Engineers Comments Regarding Surface Water Drainage

Application Reference:	R/62/26/PL	Reviewer Reference:	ADC/EXT5/AF
Planning Officer:	Hebe Smith	Date of Review:	10/07/2026
Site Name:	Croft Works 52 Mill Lane Rustington BN16 3JN		
Application Description:	Demolition of existing commercial buildings, erection of 3 No 2 bed detached bungalows with integral garaging and creation of 3 individual vehicular crossovers onto Fircroft Crescent. This application is in CIL Zone 4 and is CIL Liable as new dwellings.		
Assessment Number:	1

Response	Objection
----------	-----------

Proposed Drainage Layout

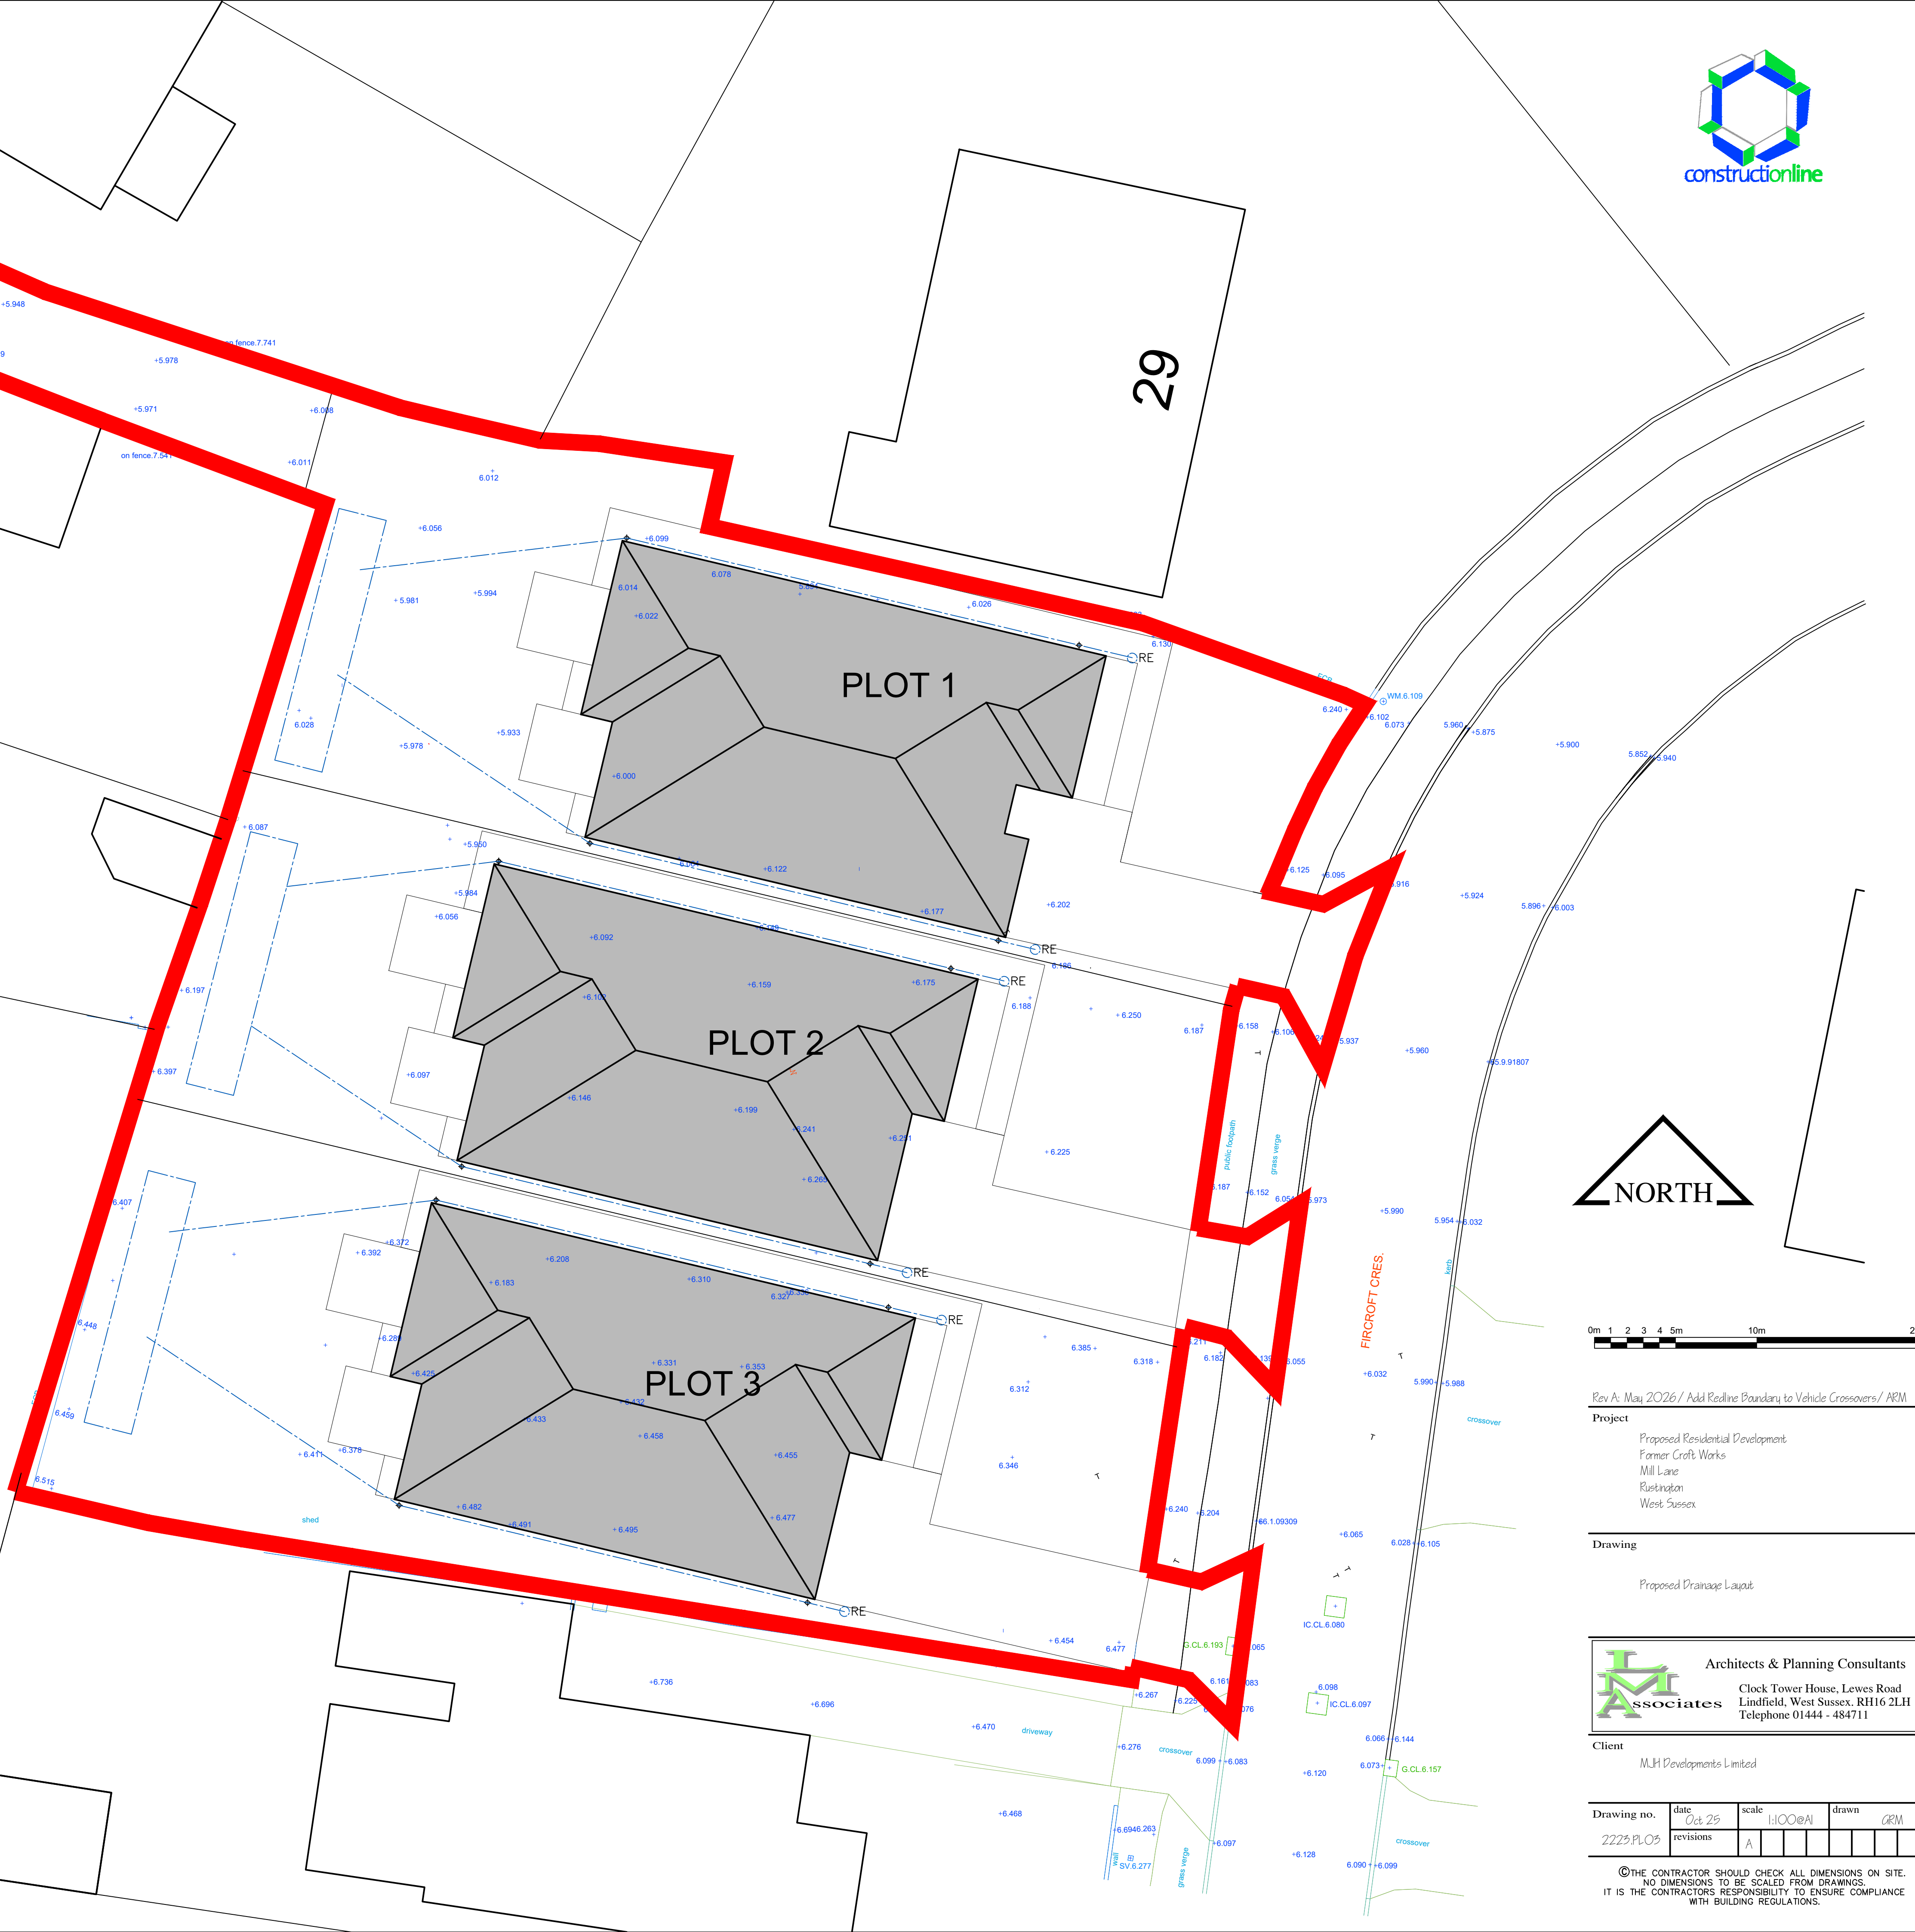
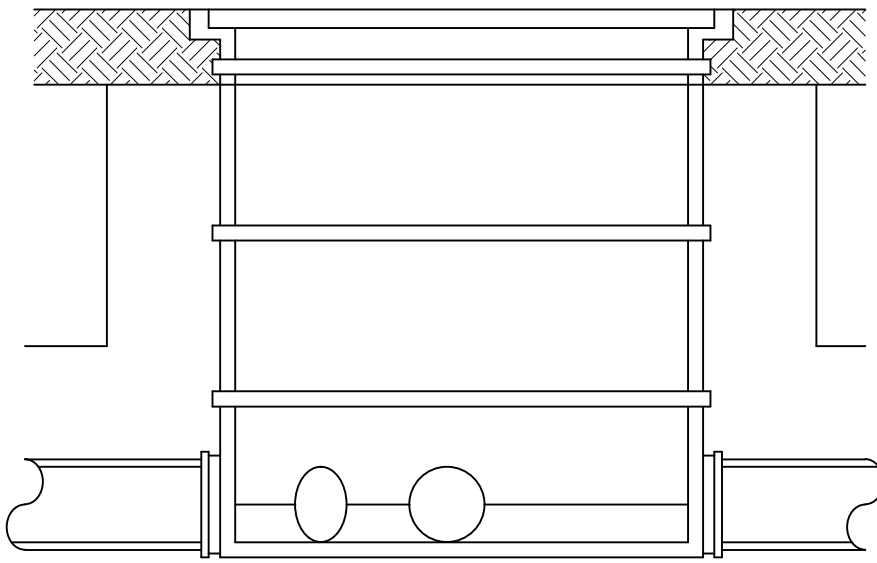
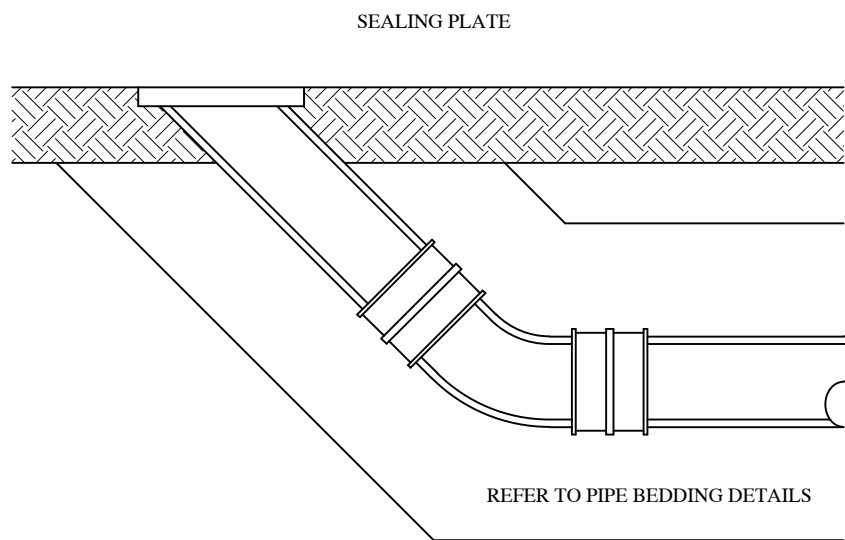
- 3.2. Urban creep has not been added.
- 3.3. Cv values should be set to 1.0.
- 3.4. Currently both the base and sides for both the soakaway and permeable paving have been allocated the infiltration coefficient. Infiltration should be applied to the sides of soakaways and the base of permeable paving.

- 7.1. The soakaways are close to the property boundary and are indicated to be 2.5-3 metres deep which may cause buildability issues. Consideration should be given to moving the soakaways away from the boundary if suitable offset distances can be maintained from building foundations.
- 7.2. A maintenance plan should be provided to the homeowners to provide information on the maintenance of the permeable pavements.

SOAKAWAY DETAIL

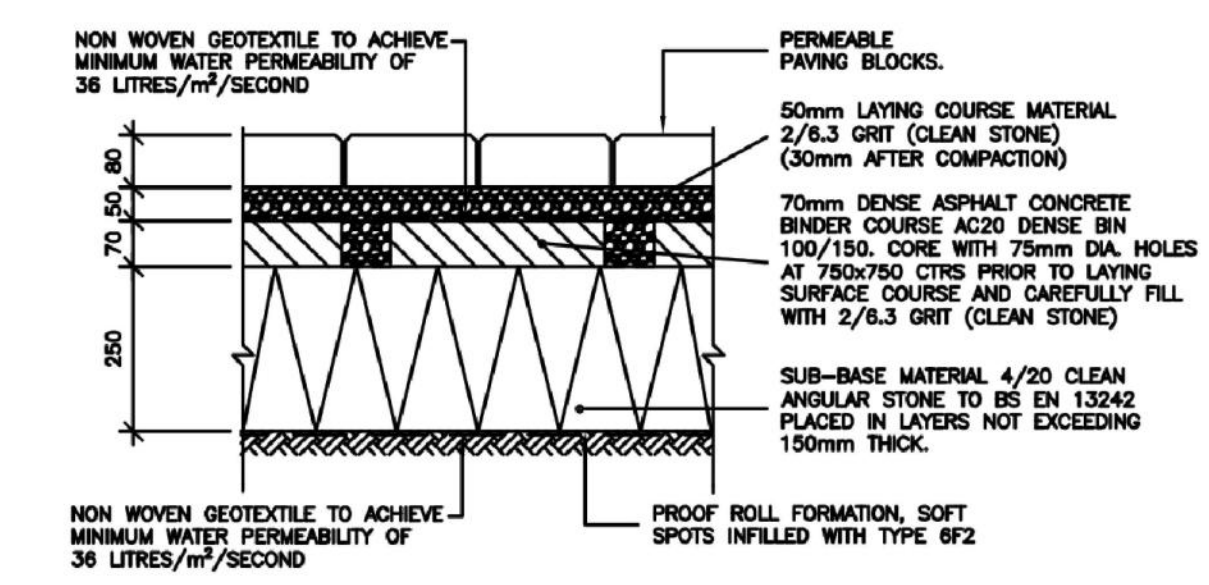
- 0.9. Both sets of testing are at a different base level to the design and possibly with a base within a different stratum. The initial sections of the deeper structureless chalk may have very low infiltration as structureless or 'putty chalk' is known to exhibit. The designer should review this and ensure the testing is applicable to the design.

ACCESS ROAD PERMEABLE BLOCK PAVING CONSTRUCTION DETAIL

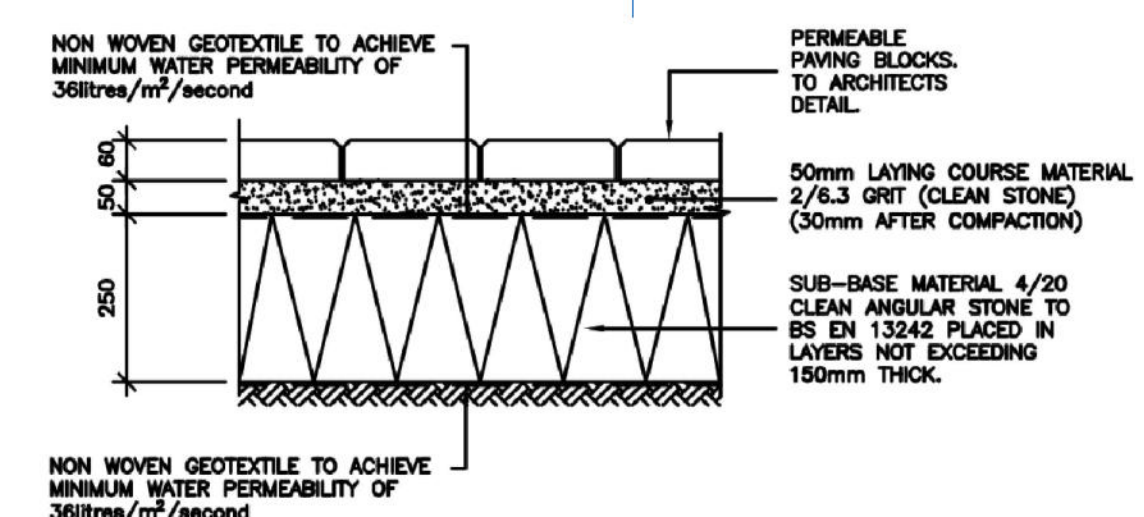
- 1.6. There is no testing at shallow depth for the infiltration from the permeable driveway design.
- 1.7. The design is not currently in accordance with the requirements of the NSfS (Standard 1).
Therefore, we **object** to the application.
